**WELWYN HATFIELD BOROUGH COUNCIL  
EXECUTIVE DIRECTOR - PLANNING, PUBLIC PROTECTION AND GOVERNANCE**

**DELEGATED APPLICATION**

**Application No:** 6/2020/0743/HOUSE  
**Location:** 6 Park Close Hatfield AL9 5AY  
**Proposal:** Erection of a single storey rear extension  
**Officer:** Mr Tom Gabriel

dwg title:
 PROPOSED ELEVATIONS

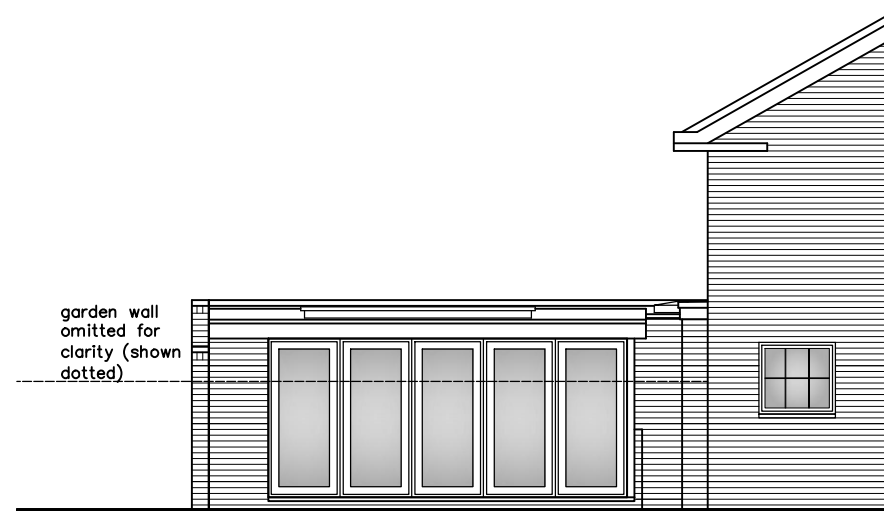
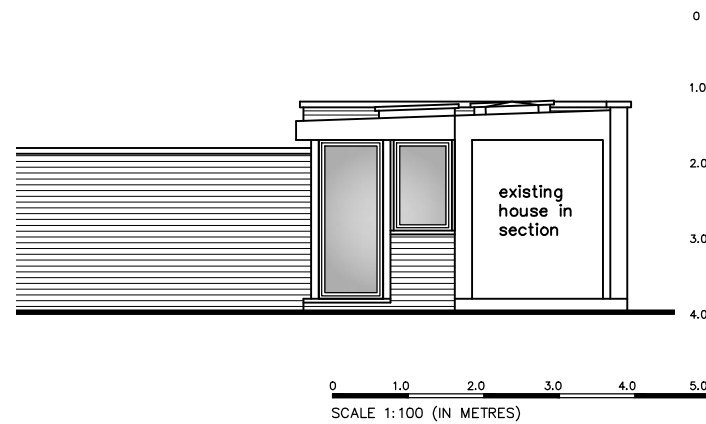
The proposed extension would represent a limited addition to the dwelling which, subject to the use of matching materials of construction, would not cause harm to the Conservation Area. Though the proposed rooflights would project above the roof of the extension, they would be concealed behind a parapet wall and would not harm the area. The extension would preserve the character and appearance of the Conservation Area.

**Comment** (if applicable): Subject to a condition requiring the proposed materials to match the existing dwelling, the proposal would reflect the character of the dwelling. The rooflights would not be prominent or harmful features of the proposal and would not harm the character of the dwelling.

1. The brickwork, roof tile, bond, mortar, windows, detailing, guttering, soffits and other external decorations of the approved extension/alterations must match the existing dwelling/building in relation to colour and texture.
